## **Land west of Pagham Road, Pagham**

Reserved Matters application  
(P/114/24/RES)

## **Bargate responses to comments made by consultees**

February 2025

Project Land West of Pagham Road
Drawing House Type 2x1M - Option 2
Floor Plans
Client Bargate Homes
Job no. BARG230419 Date January 2025
Dwg no. HT.2x1M.p2 Rev. B
Author CJB Checker Scale 1:100 at A3
Status PLANNING Office Romsey
Client ref.

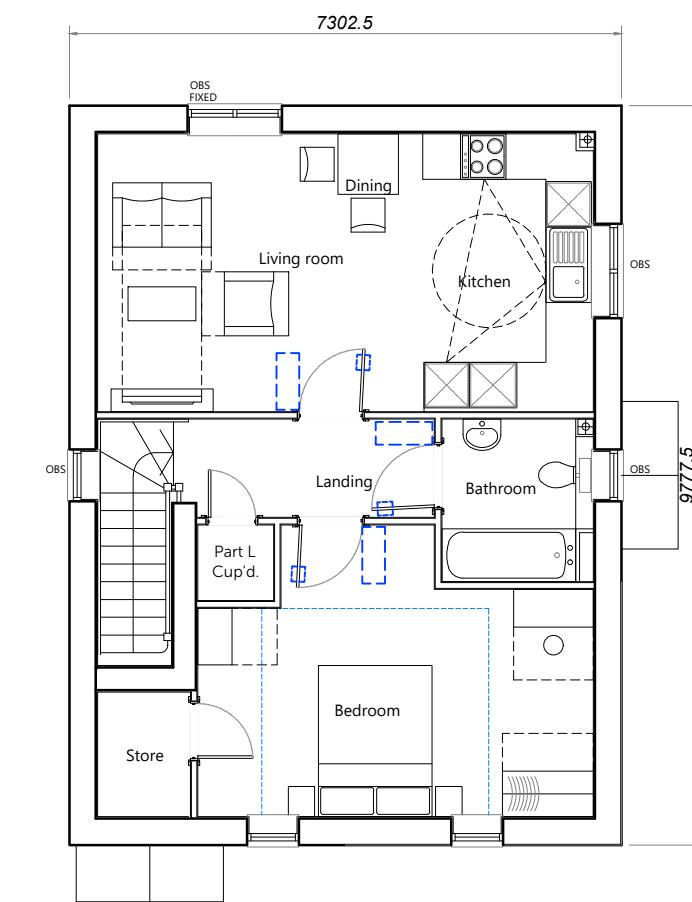
Statutory Consultee	Summary of key points	Response
	<p>- Rear of plot 35 FOG (has an FF bathroom window) to rear of 26/27 (2 FF bed windows) is only 12.1-13.1m (21m) – will be ok provided 35's bathroom window is O/G.</p> <p>- Rear of plots 36/37 (has FF rear landing window) to rear of 25 (FF 2 x bed, 1 bath windows) is only 16-16.6m (21m) – will be ok provided 37's landing window is O/G.</p> <p>- Rear of plot 8 (2 x FF bed windows) to rear of plot 13 (FF bath window) is only 13.2m (21m) – will be ok provided 13's bath window is O/G.</p>	<p>in the landing <u>and fixed obscured glazed window in the living room</u> of plot 34.</p> <ul style="list-style-type: none"> <li>• HT.2BFOG-2.p Rev C and HT.2BFOG-2.e Rev C, which continues to show an obscure glazed first floor window in the bathroom, <u>alongside the introduction of a fixed obscured glazed window in the living room</u> of plot 35.</li> <li>• HT.2x1M.p2 Rev B and HT.2x1M.e2 Rev B, which show the introduction of an obscure glazed first floor window in the landing <u>and fixed obscured glazed window in the living room</u> of plot 37.</li> <li>• HT.2BFOG-1.p Rev C and HT.2BFOG-1.e Rev C, which show the introduction of an obscure glazed first floor window in the bathroom of plot 13.</li> </ul>

Project	Land West of Pagham Road
Drawing	House Type 2x1M - Option 1 Elevation
Client	Bargate Homes
Job no.	BARG230419
Dwg no.	HT.2x1M.e1
Author	MWP Checker
Status	PLANNING
Office	Romsey
Client ref.

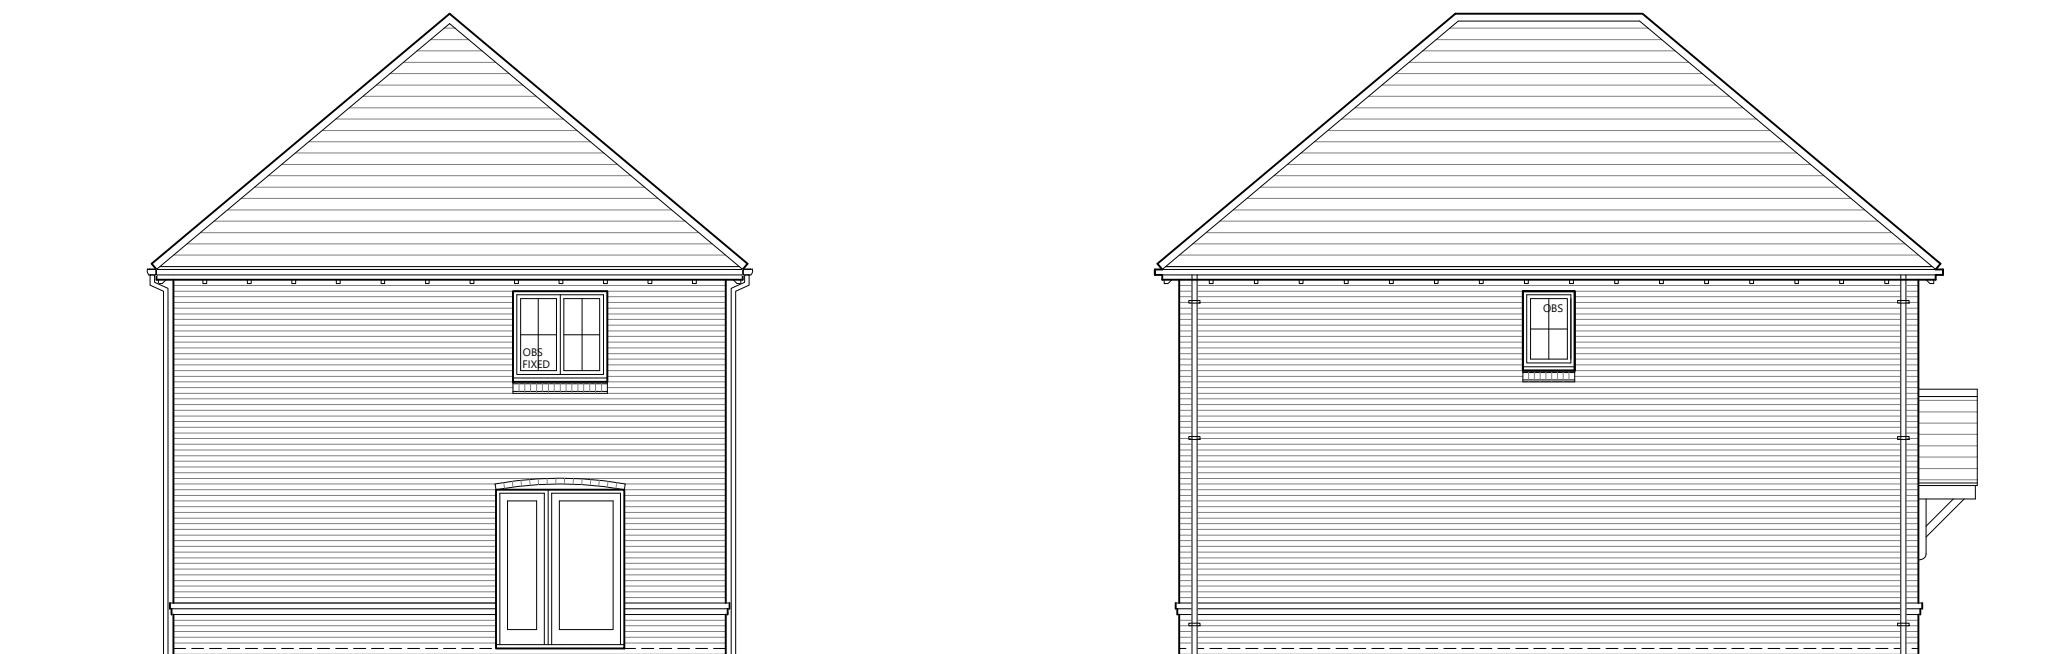
<p>Interface distances/relationships issues to be resolved through obscure glazing:</p> <p>Rear of plot 29 (rear FF bath/bed windows) to rear of 33/34 (FF landing window) is 13m (21m) – will be ok provided 34's landing window is O/G.</p> <p>- Rear of plots 33/34 (FF landing window) to rear of 30 (2 FF bed windows) is only 12.3m (21m) – will be ok provided 34's landing window is O/G.</p>	<p>Obscure glazing has been provided as requested. Please refer to the following updated plans and explanation:</p> <ul style="list-style-type: none"> <li>• HT.2x1M.p1 Rev C and HT.2x1M.e1 Rev C, which show the introduction of an obscure glazed first floor window</li> </ul>

Project Land West of Pagham Road  
Drawing House Type 4.1 - 2 Block  
Elevations

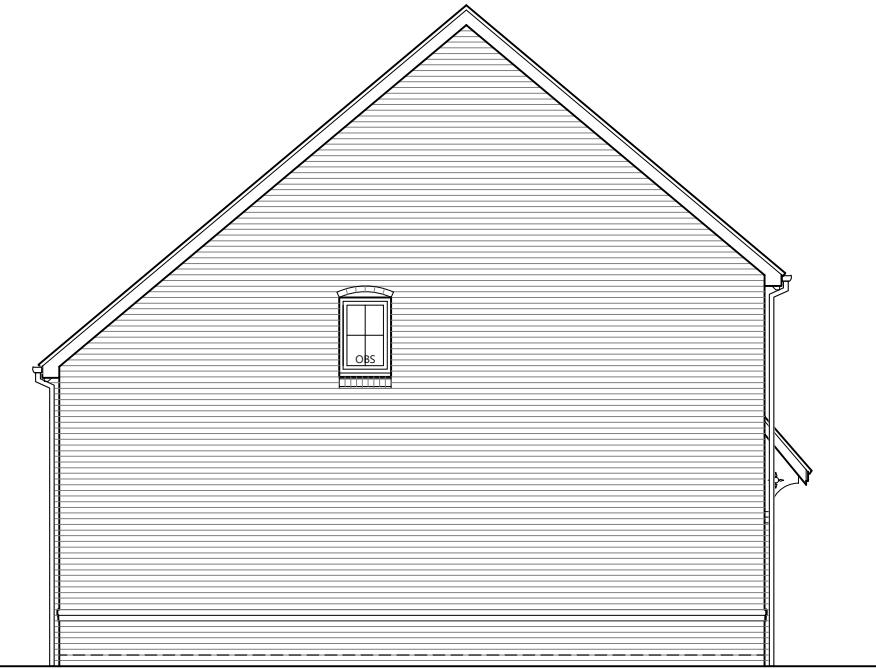
Statutory Consultee	Summary of key points	Response
	<p>Interface distances/relationships to be resolved:</p> <p>I visited Mill Farm yesterday. You will note I raised concerns at our meeting with 4 particular interface relationships to off-site dwellings:</p> <ul style="list-style-type: none"> <li>- Southern elevation of plots 36/37 (FF bed, bath, kitchen windows) to rear of 22 Mill View Close is only 13.8m (ADG requires 16/21m – nb the ADG does not specify a front-to-rear specific distance).</li> <li>- Flank of 21 (FF Landing/bath window) to rear of 23 Mill Close is 12.8m (14.5m)</li> <li>- Front of plots 33/34 (FF bed, bath, kitchen windows) to the rear of 7 Old Barn Close is 15.7m or 12.6m to its conservatory (need 16-21m).</li> <li>- Rear of plots 14/15 (2 x FF bed windows) to rear of 8 Mill View Close is 16-17.2m (14.5m to edge of conservatory) (need 21m).</li> </ul> <p>Having visited the site, I observed a high hedge protecting the amenities of 22 and 23 Mill View Close and I note this is being retained. On this basis, I consider their amenities to be protected. However, I retain concerns (which my Team Leader agrees with) concerning the impact on 7 Old Barn Close and 8 Mill View Close which both have conservatories and do not have the benefit of hedge protection (no 7 does have some but there is gap where the conservatory is). I acknowledge that it is proposed to fill in any gaps, but this may take time to grow, and, in the meantime, these two park homes will be subjected to overlooking at close quarters. You will note that we raised these same issues at the pre-app stage. I</p>	<p>Please refer to the following updated plans and explanation:</p> <ul style="list-style-type: none"> <li>• HT.2x1M.p1 Rev C and HT.2x1M.e1 Rev C (plots 33/34, at first floor level) have been updated as follows, providing an acceptable relationship with the rear of 7 Old Barn Close: <ul style="list-style-type: none"> <li>- Removal of the southern bedroom window.</li> <li>- Introduction of western bedroom windows.</li> <li>- Introduction of obscure glazing on the kitchen window (southern elevation).</li> </ul> </li> <li>• HT.4.1(2blk).p Rev C and HT.4.1(2blk).e Rev B (plots 14/15, at first floor level) have been updated as follows, providing an acceptable relationship with the rear of 8 Mill View Close: <ul style="list-style-type: none"> <li>- Roof line has been dropped.</li> <li>- Introduction of velux windows on the southern elevation.</li> </ul> </li> </ul>

Statutory Consultee	Summary of key points	Response
	<p>would not feel comfortable approving a layout which conflicts with the ADG in respect of the relationship to these two existing homes.</p>	<p>While not flagged as a concern, other changes that have been made to the house types proposed along the site's southern boundary – to further assist in ensuring an acceptable relationship with the existing dwellings to the south (and proposed dwellings to the north) – include the following:</p> <ul style="list-style-type: none"> <li>• HT.2x1M.p2 Rev B and HT.2x1M.e2 Rev B (plots 36-37, at first floor level) have been updated as follows: <ul style="list-style-type: none"> <li>- Removal of the southern bedroom window.</li> <li>- Introduction of western bedroom windows.</li> <li>- Introduction of obscure glazing on the kitchen window (southern elevation).</li> </ul> </li> <li>• HT.B(3blk).p Rev C and HT.B(3blk).e Rev C (plots 16-18, at first floor level) have been updated as follows: <ul style="list-style-type: none"> <li>- Roof line has been dropped.</li> <li>- Introduction of dormer windows on the northern elevation.</li> </ul> </li> </ul>
